CITY OF PORTLAND BUILDING PERMIT

Located At 41 MONTREAL ST

Job ID: 2012-06-4137-ALTR

has permission to Second Floor Addition for 1 Bedroom & Office Space

A1.4

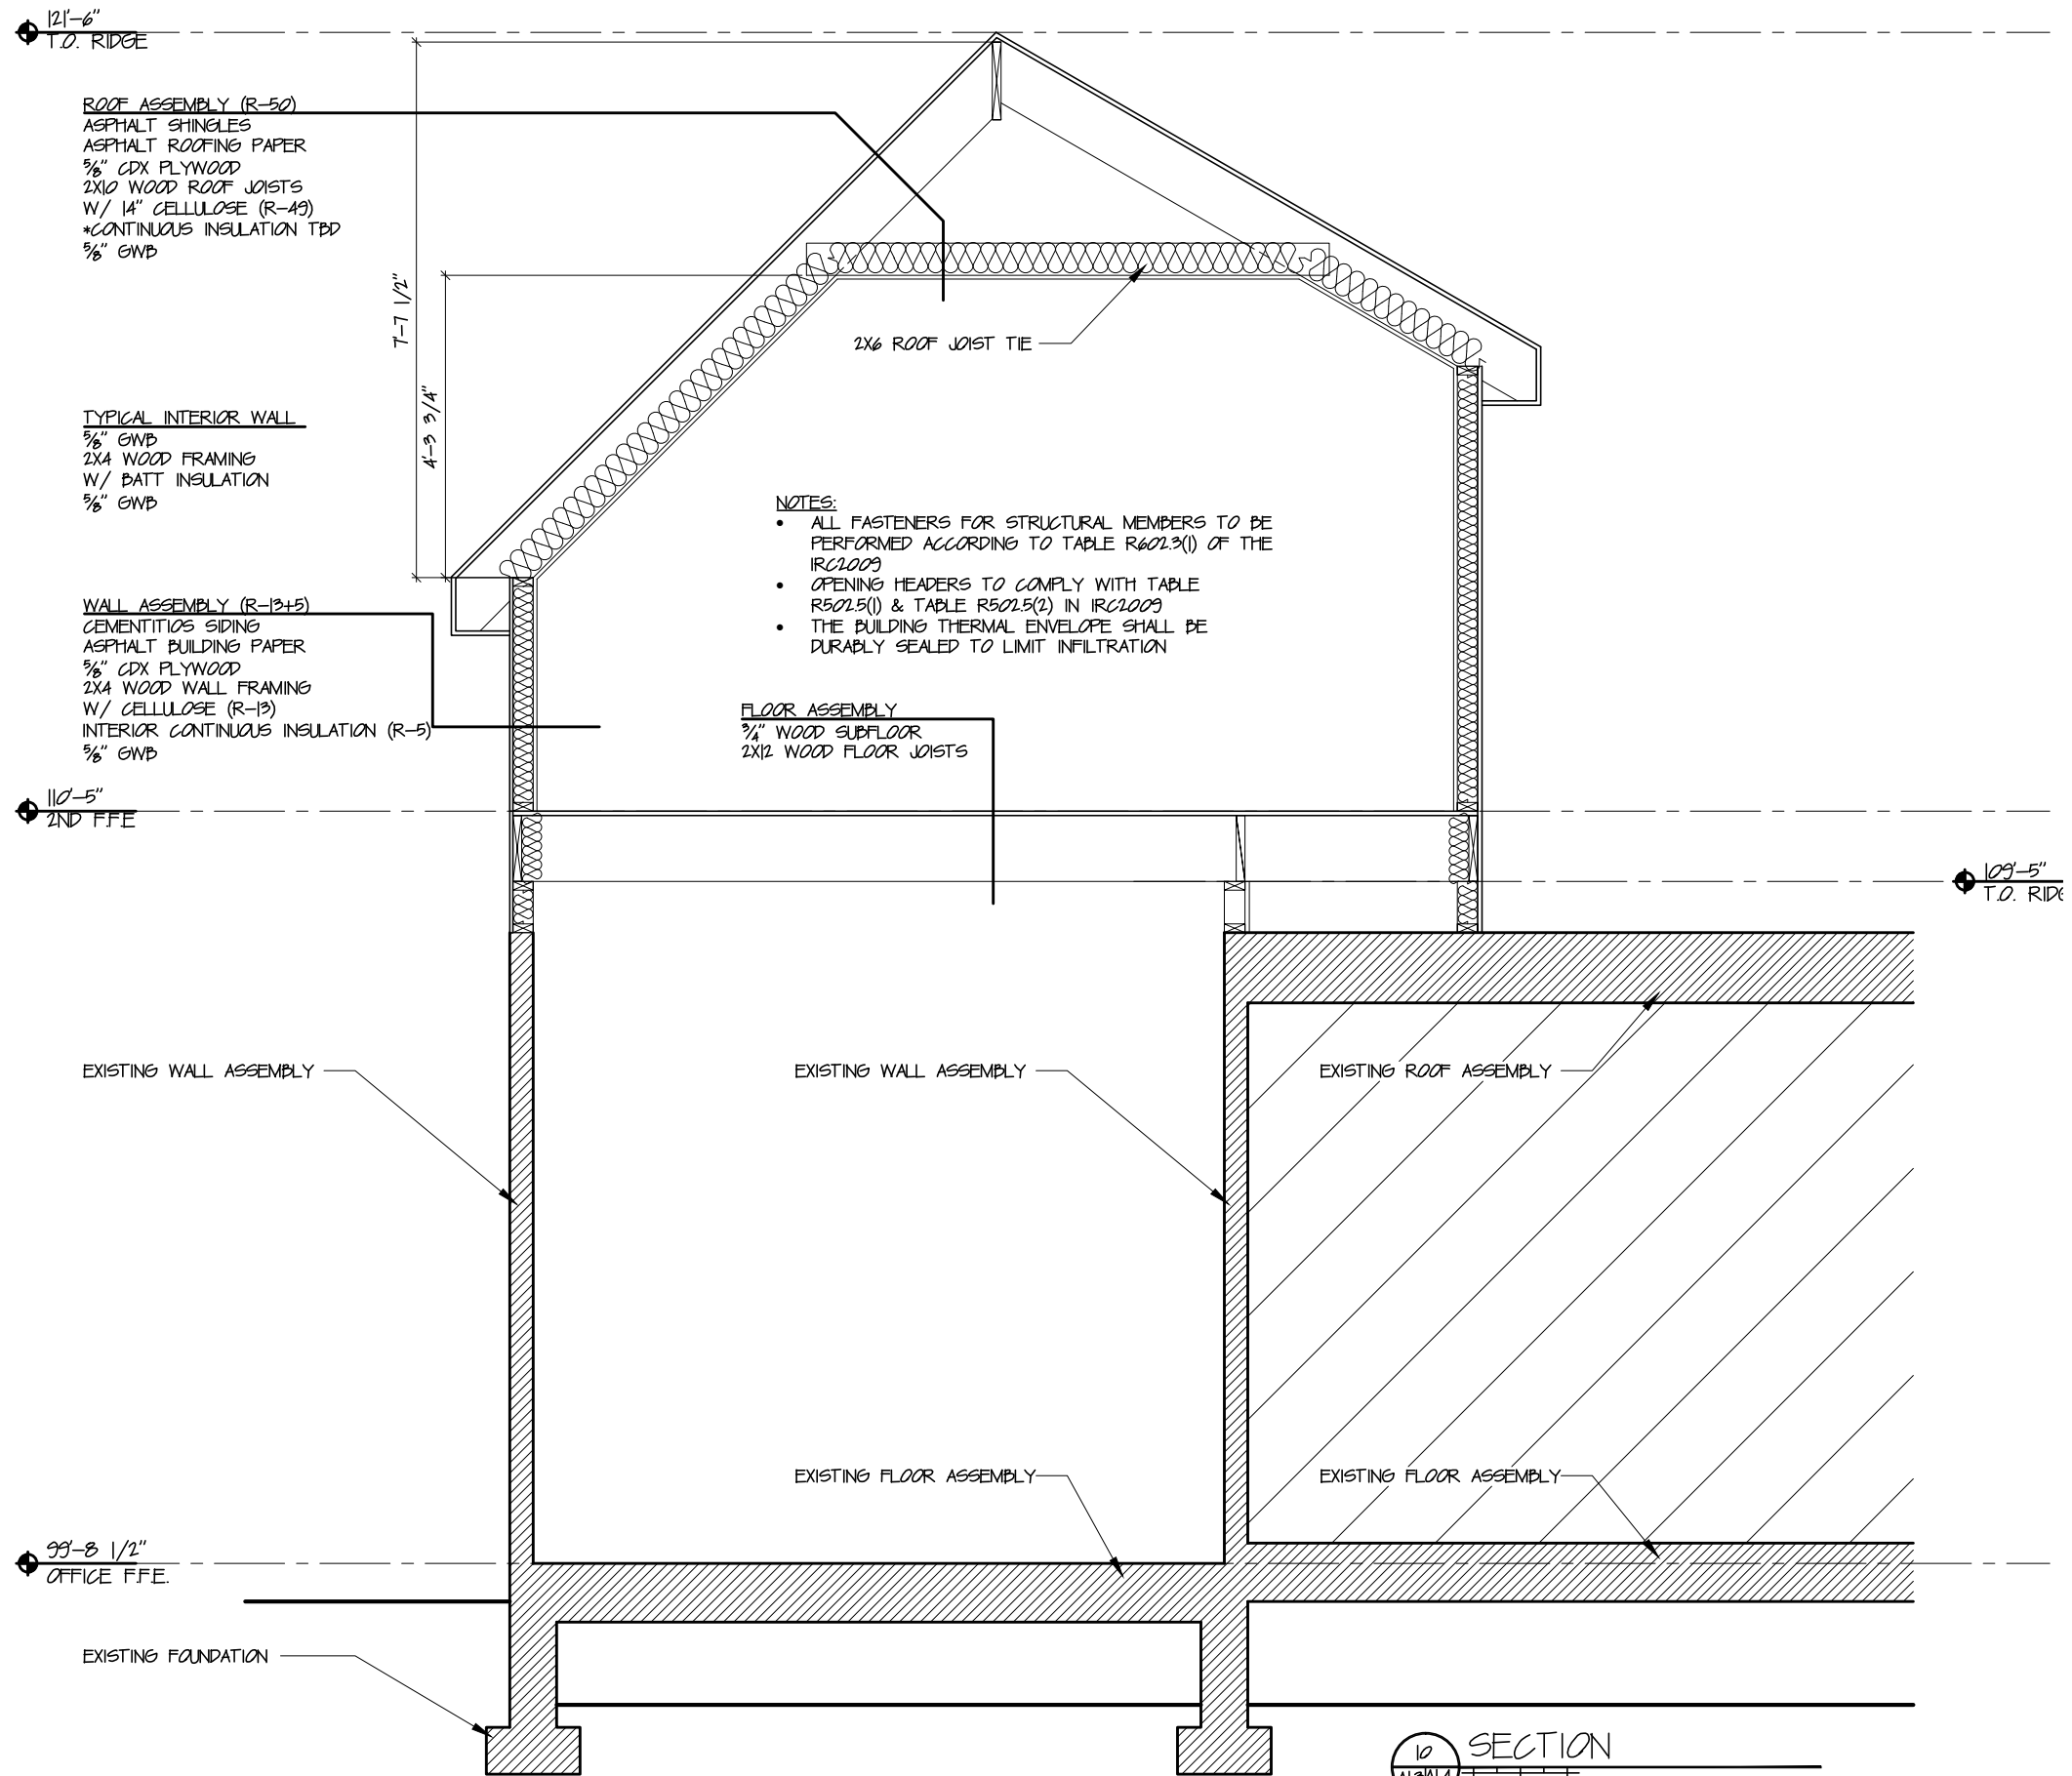
17' over
30" will
add attic
access

2x10
11' span

15'-1" x
0.67 =
10.05 ft

Need
2x12's

2x10's - ok
will have ceiling
joist & top plate
